About the application

Application number: 2020/93637	
What is the application for?:	Demolition of clubhouse and erection of detached dwelling with associated extern
Address of the site or building:	Land Adj, 41, Stocks Bank Road, Mirfield, WF14 9QB
Postcode:

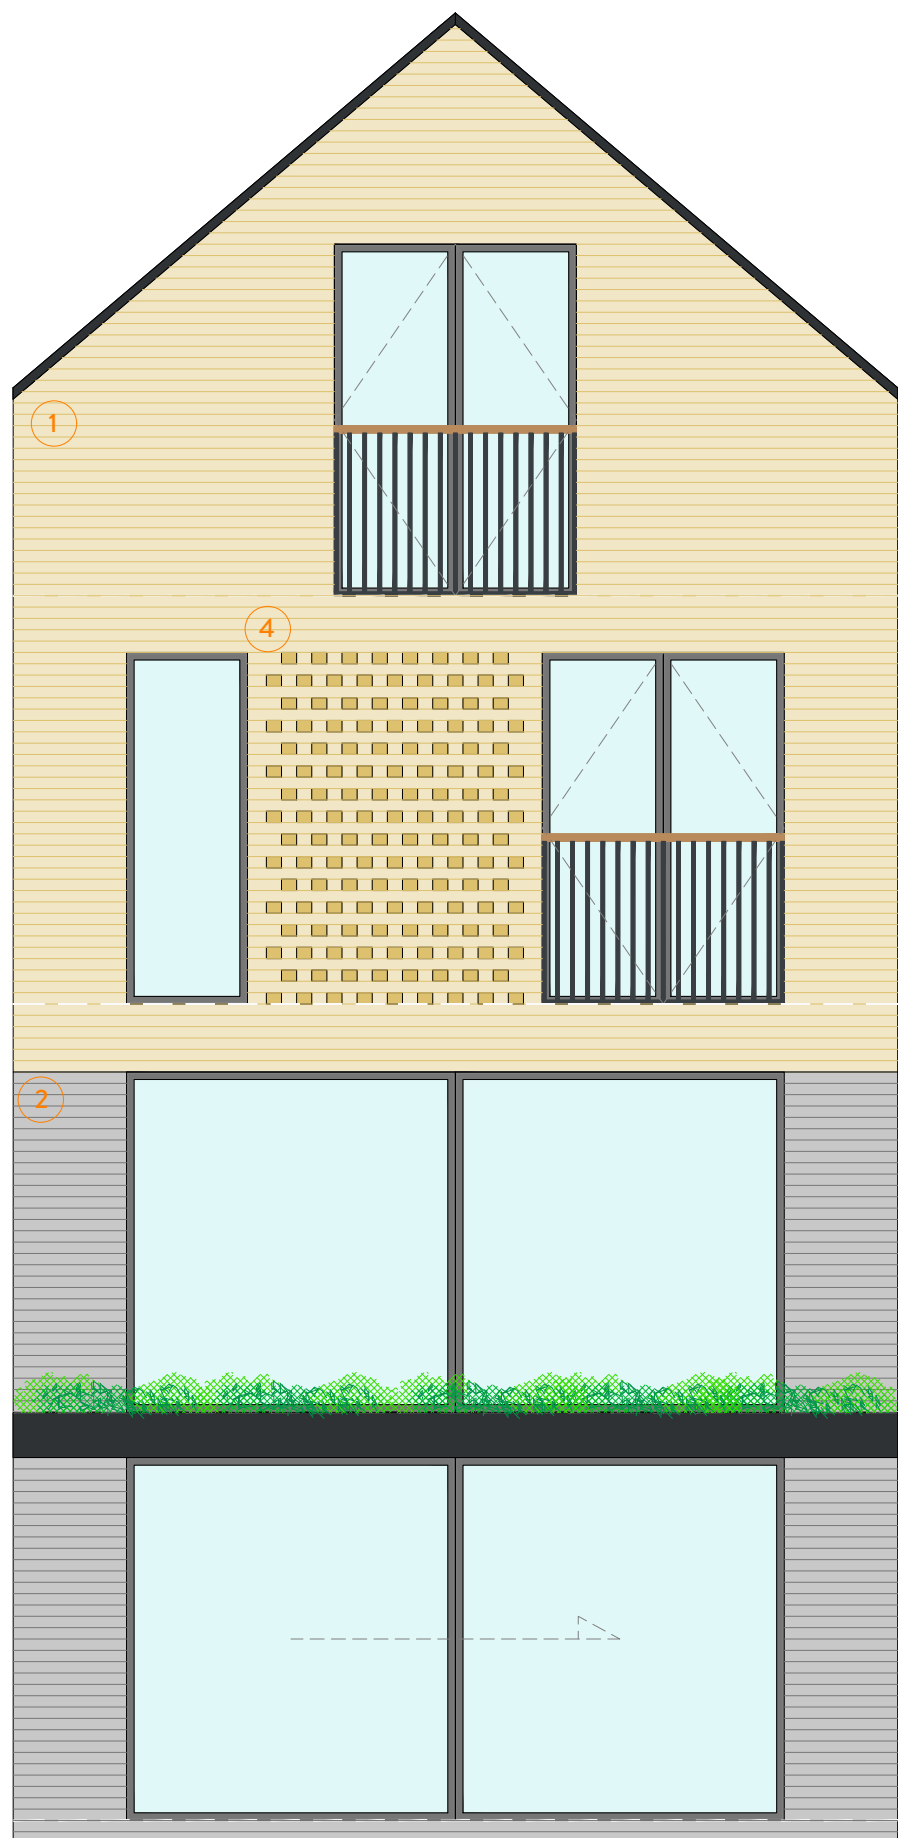
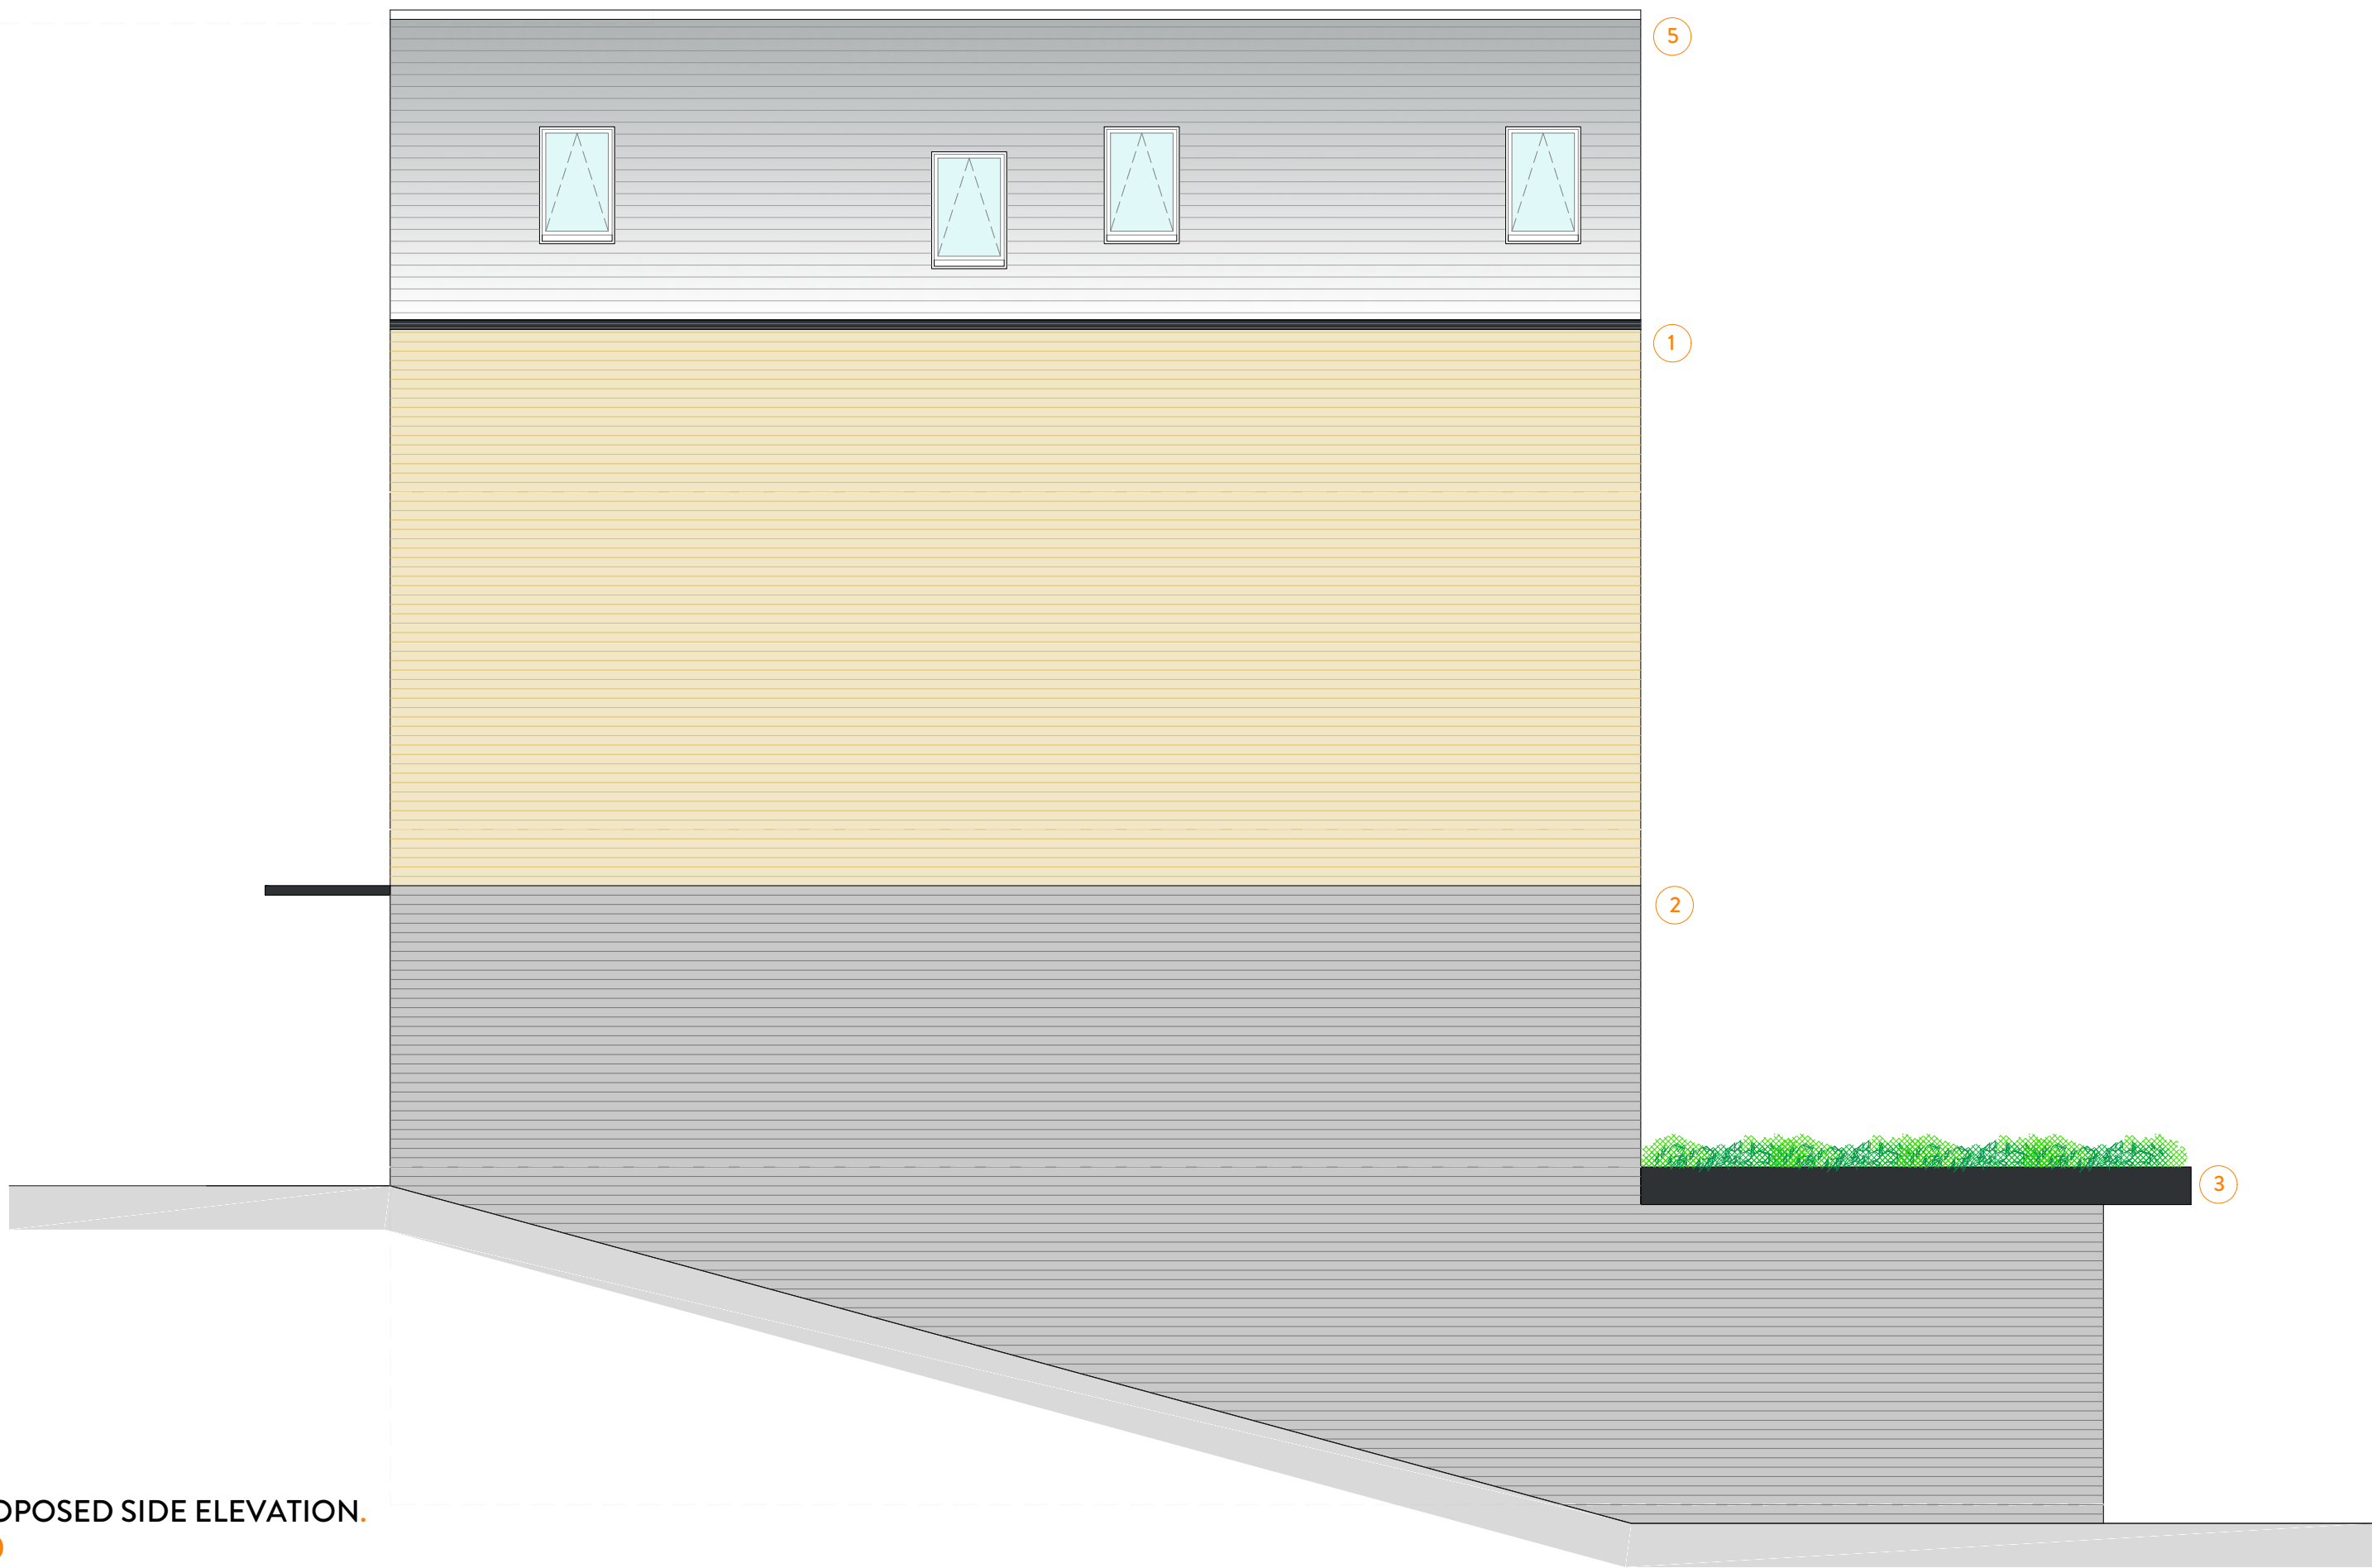
boundaries, also the development goes upwards further than is reasonable. This is definitely over-development, and to the detriment of the surrounding area, not simply the immediate neighbours. The surrounding neighbours, especially those on Bank Street, will feel the oppression of mass masonry walls and of being under constant observation. The design, with towering height and massive windows, amounts to a viewing platform or watch tower and in my opinion does not fit into this residential area. The immediate existing neighbouring gardens will lose their privacy as well as sunlight which they have held for over a hundred years.
